Tween Bridge Solar Farm

9.2 Statement of Common Ground with City of Doncaster Council

Document Reference: 9.2

Revision 4

Figure 1: Proposed Area of Preservation in Situ

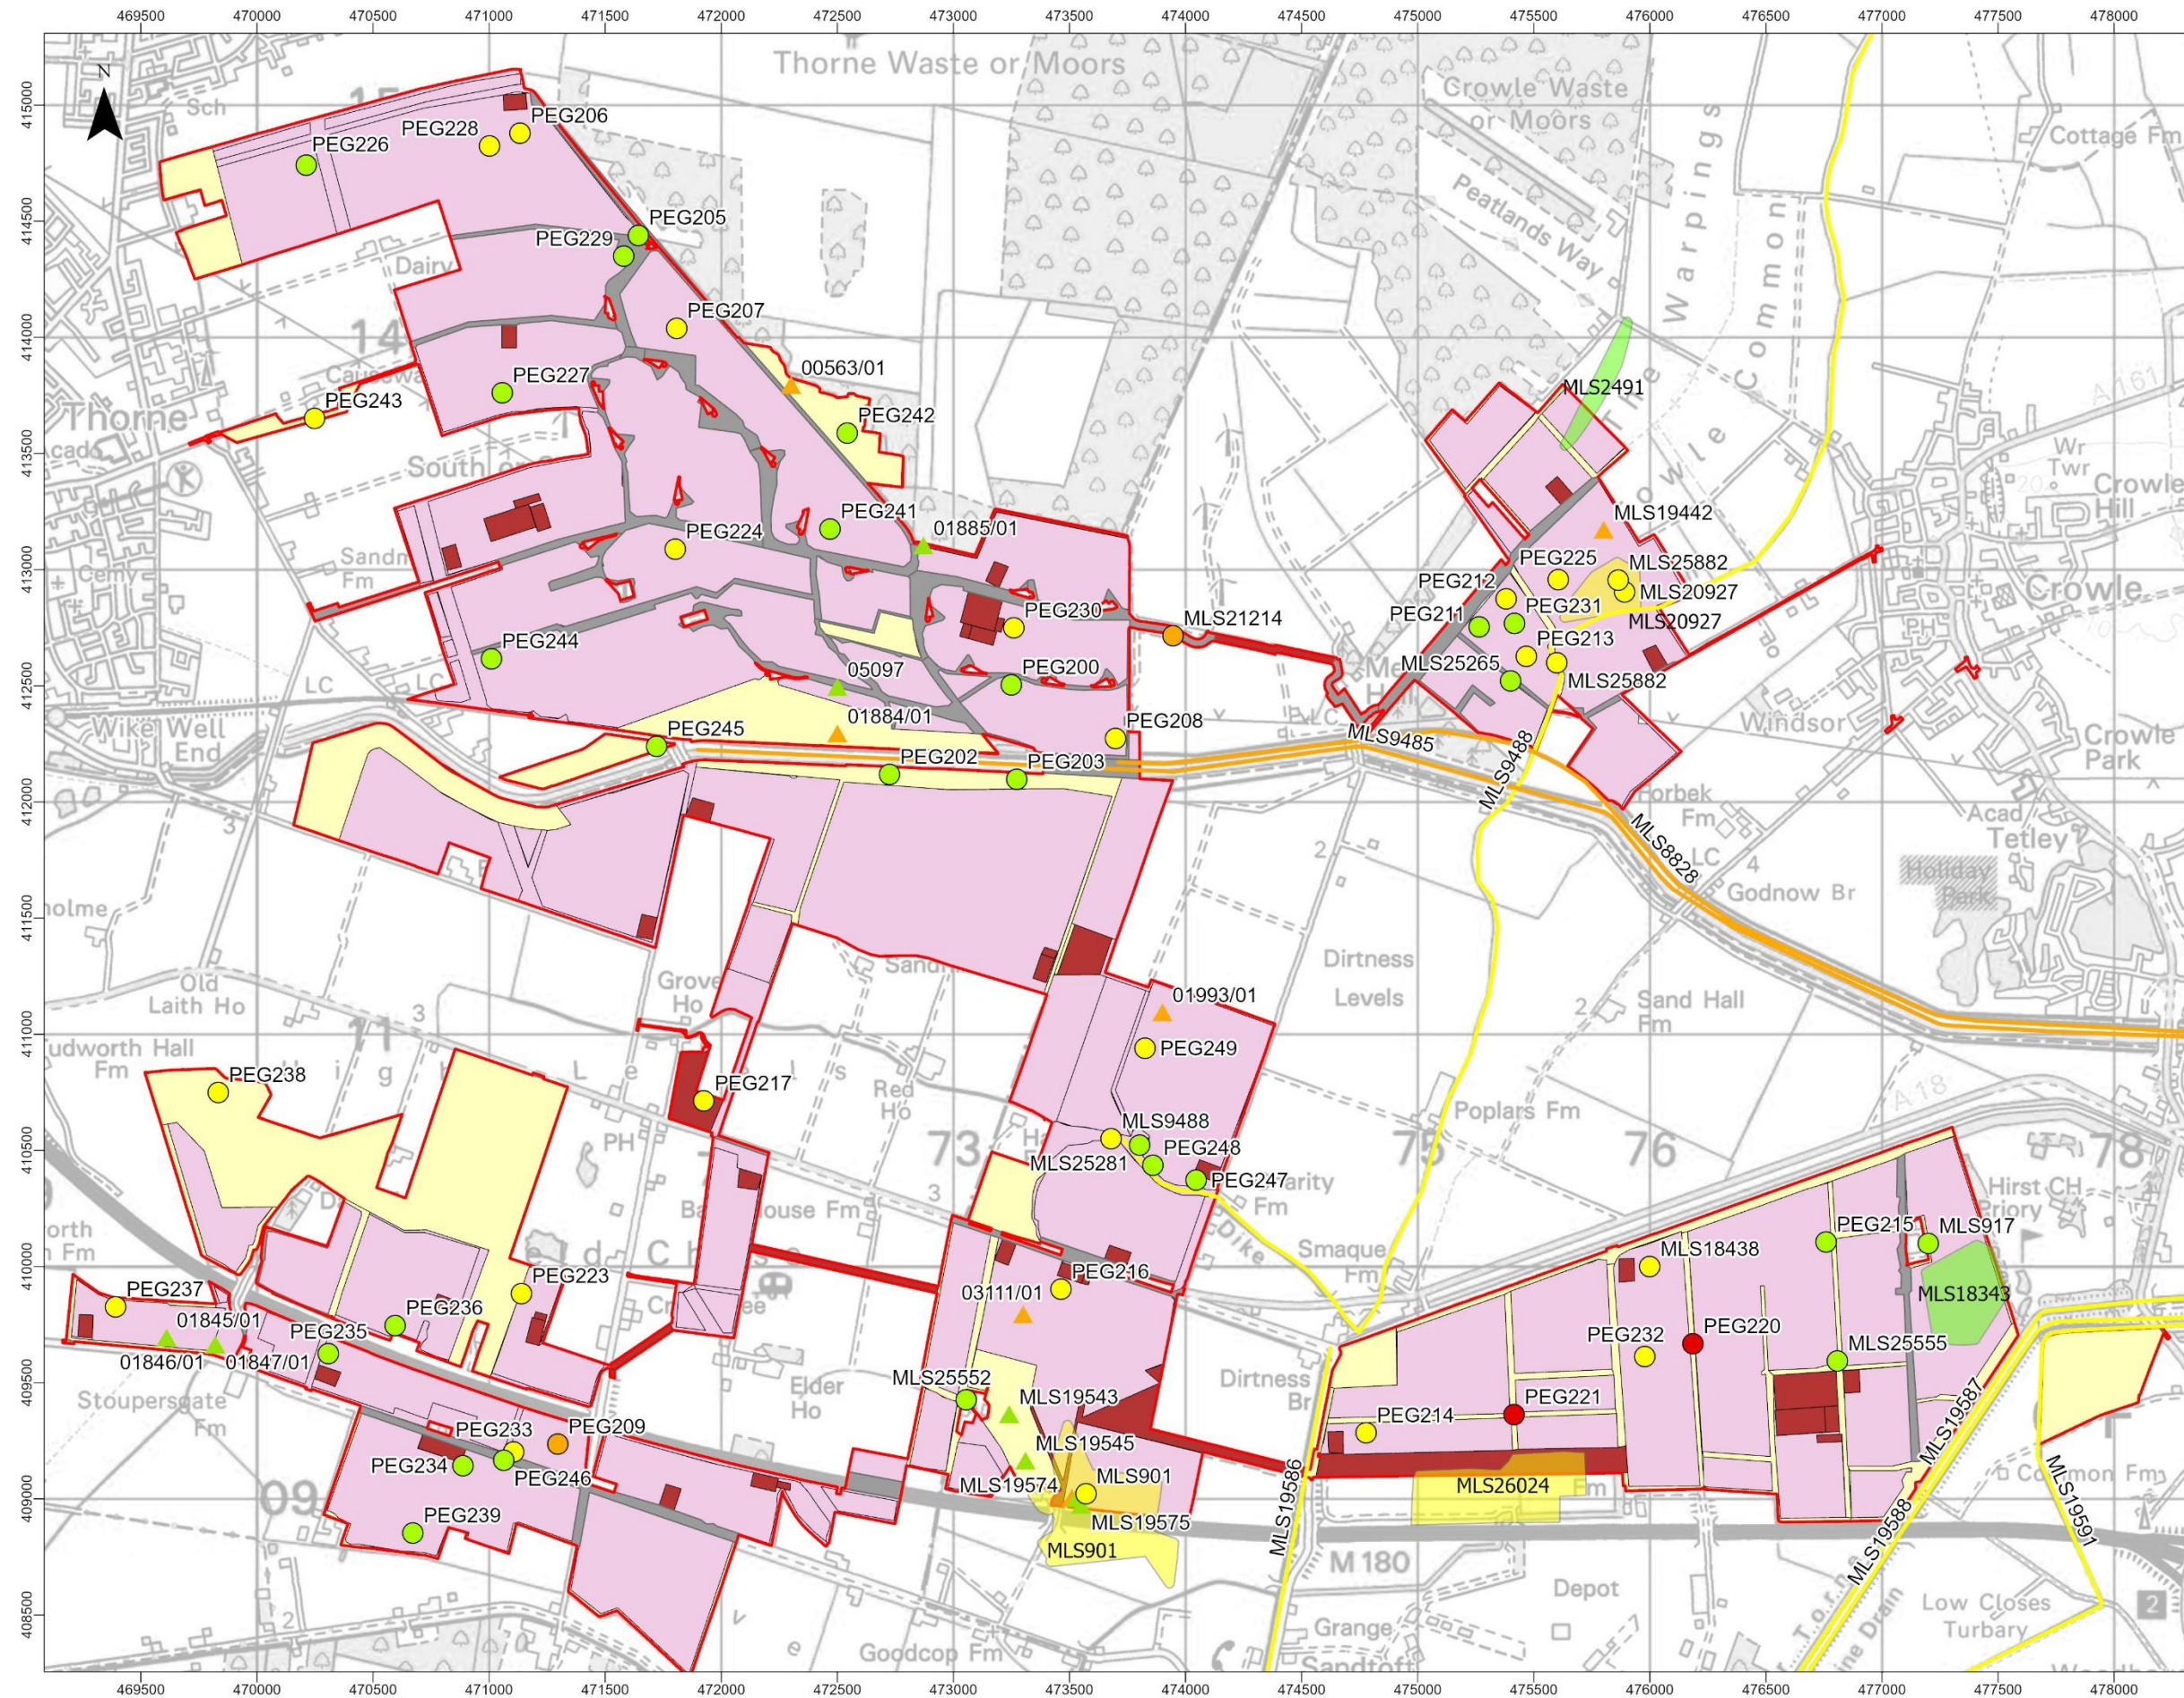
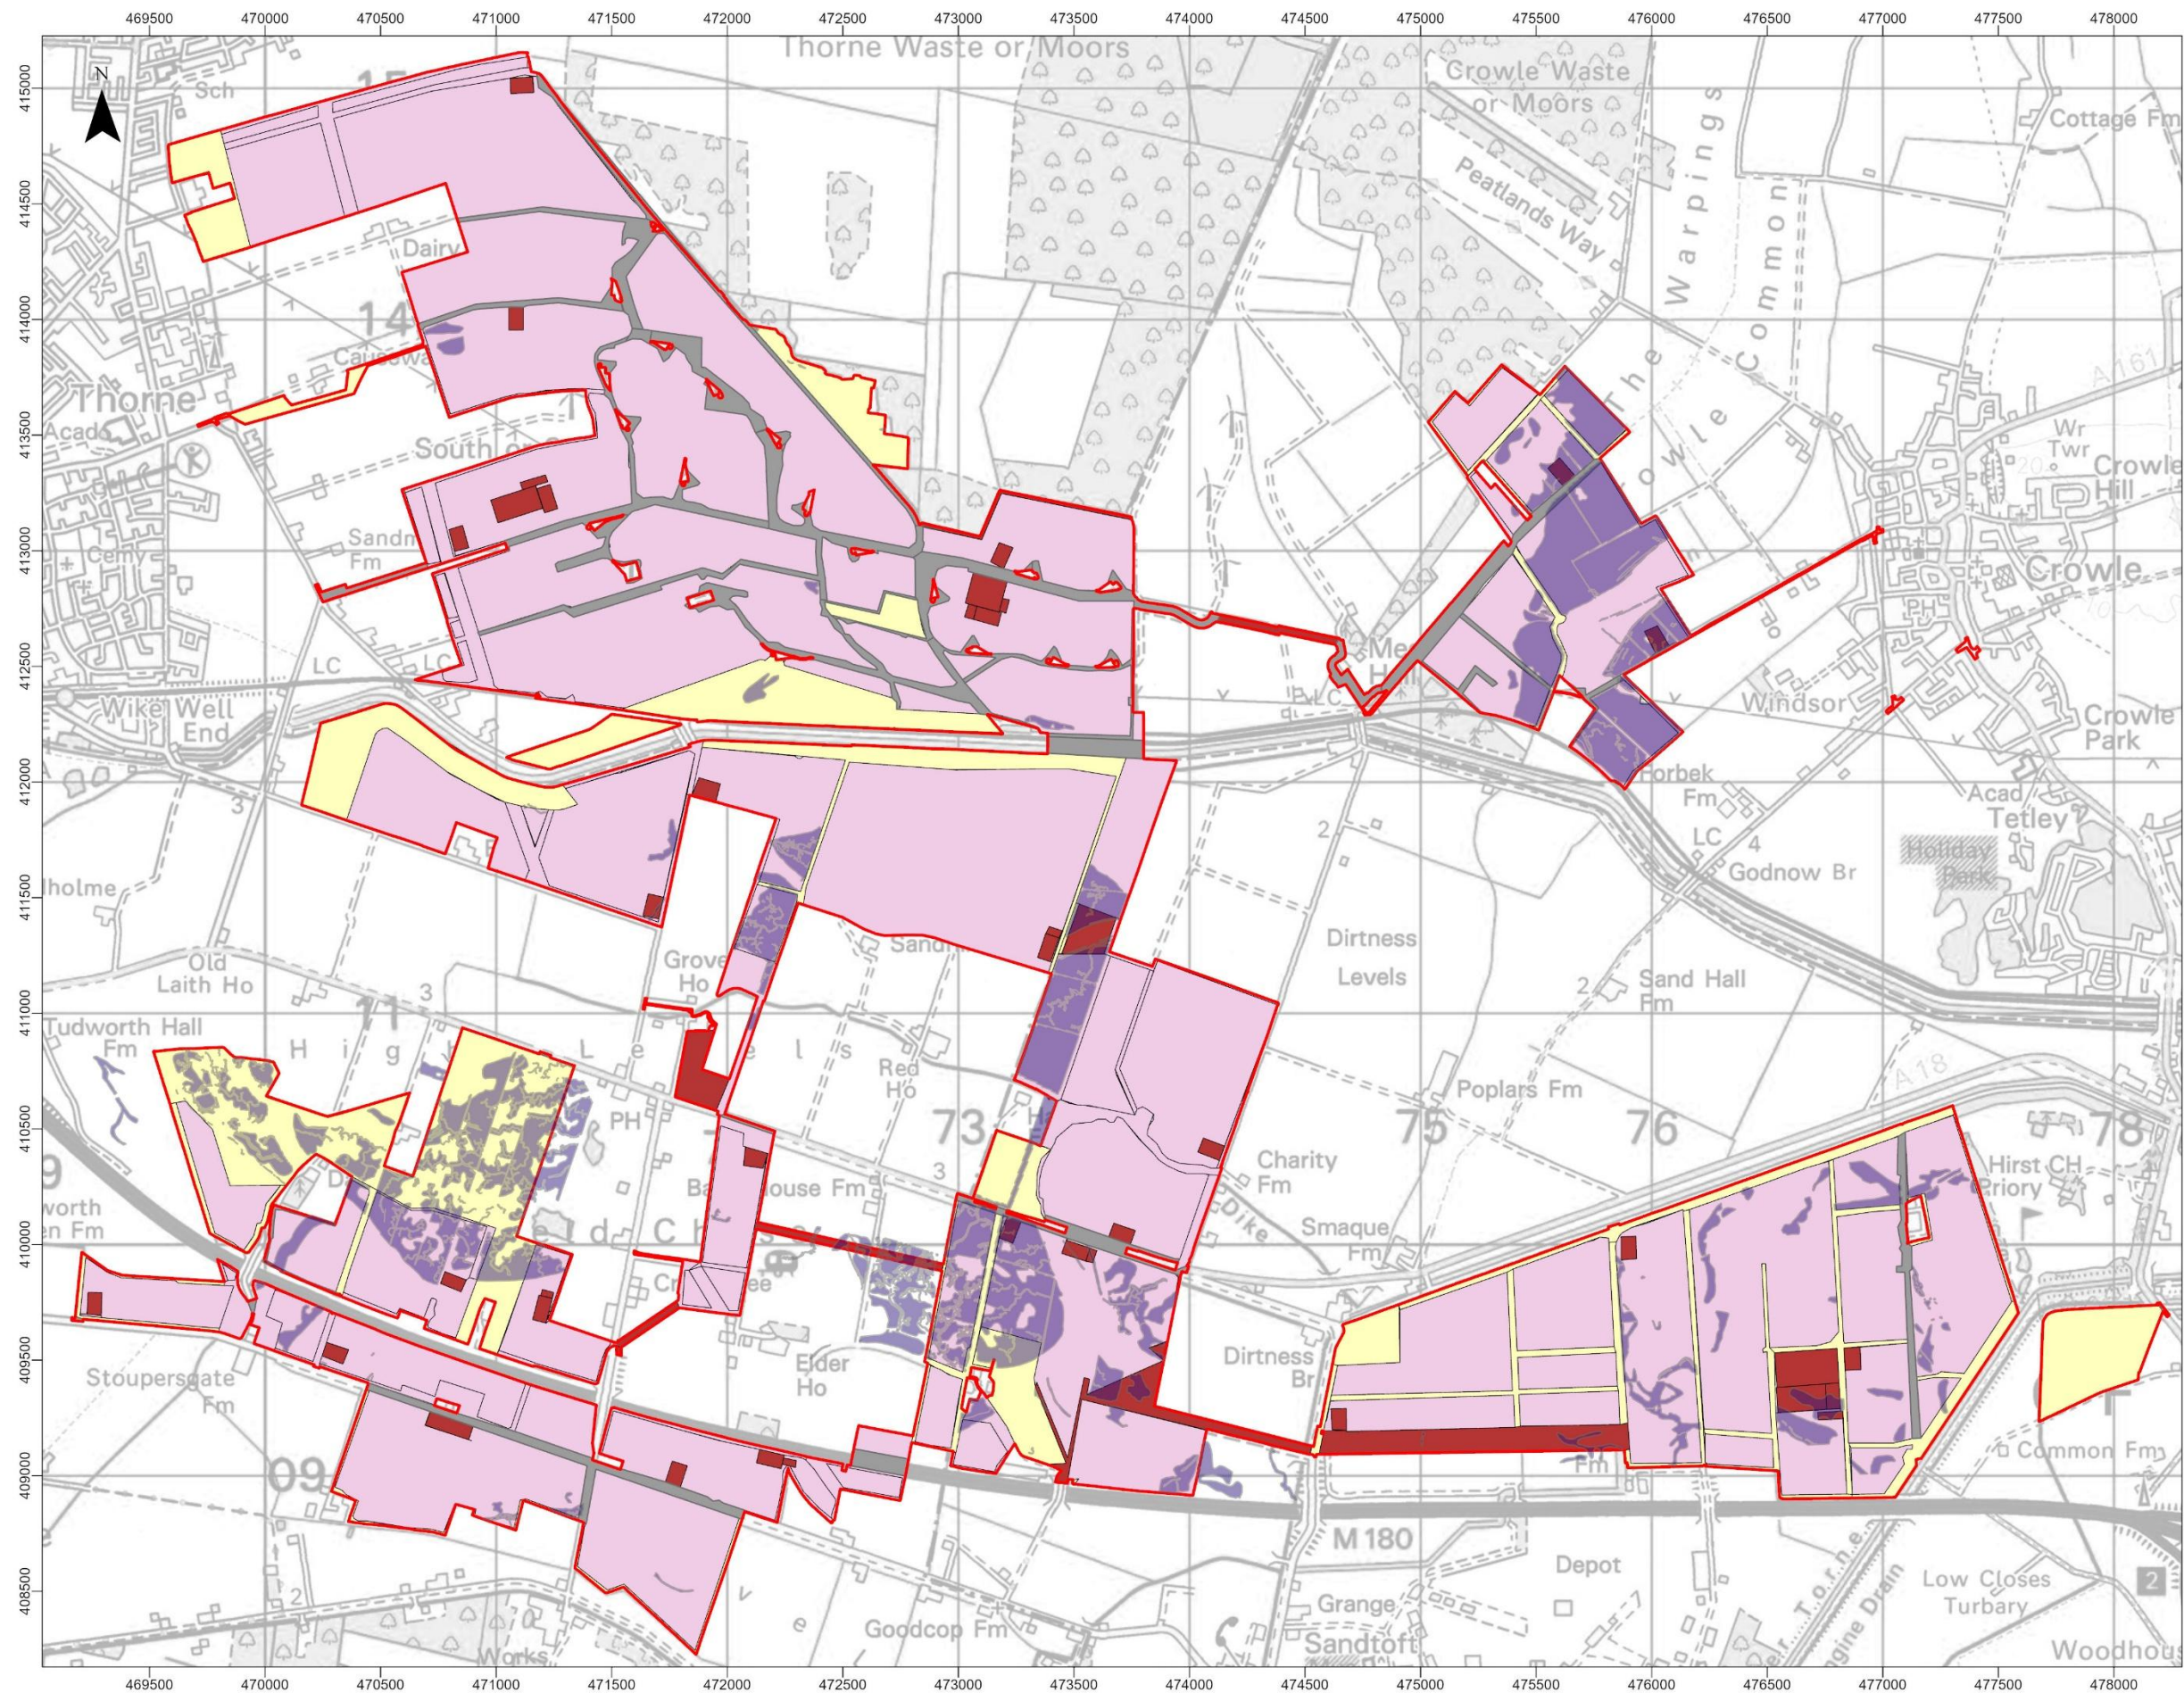
9		Paragraph 8.19 – 8.20 of RR Where the oAMS specifies mitigation measures rather than evaluation techniques, SYAS is broadly in agreement with the proposals. Micro-siting should be	The Applicant acknowledges the broad agreement. The Applicant has considered the comments provided and will continue to engage on the ES Technical Appendix 8.6 Outline	Agreed

Ref	Topic	City of Doncaster Council Position	Applicant Position	Status
		added to the options specified in paragraph 5.10 as another method of avoiding archaeological impacts. As we were not given the opportunity to review the strategy before submission, there are a number of minor revisions that should be added: • Details arrangements for monitoring the fieldwork by local authorities should be included • The oAMS should use the language of the DCO stating in paragraph 5.11 that site specific WSIs “will be substantially in accordance with this strategy” • In paragraph 5.14, archaeological advisors should be notified of the date of commencement of the archaeological fieldwork at least two weeks in advance • WSIs should also comply with regional and county standards & guidance • Fieldwalking should be undertaken on a 10m transect	Archaeological Mitigation Strategy [REP4-034] to ensure the approaches detailed are acceptable to the City of Doncaster Council. The Applicant has prepared a revised Outline Archaeological Mitigation Strategy [REP4-034]. Requirement 12 of the Draft Development Consent Order [Document Reference 3.1 Revision 8] secures the Outline AMS by stipulating that the written scheme of investigation for each development phase must be substantially in accordance with the Outline AMS. Requirement 12 also provides approval rights to the relevant local planning authority of a written scheme of investigation for each phase of development. The comments provided by SYAS on behalf of CDC have been addressed in the Outline AMS. The Outline AMS [REP4-034] has been amended to include a zoning plan following comments received from SYAS on behalf of CDC. Further amendments to the zoning plan within the Outline AMS [REP4-034] will be
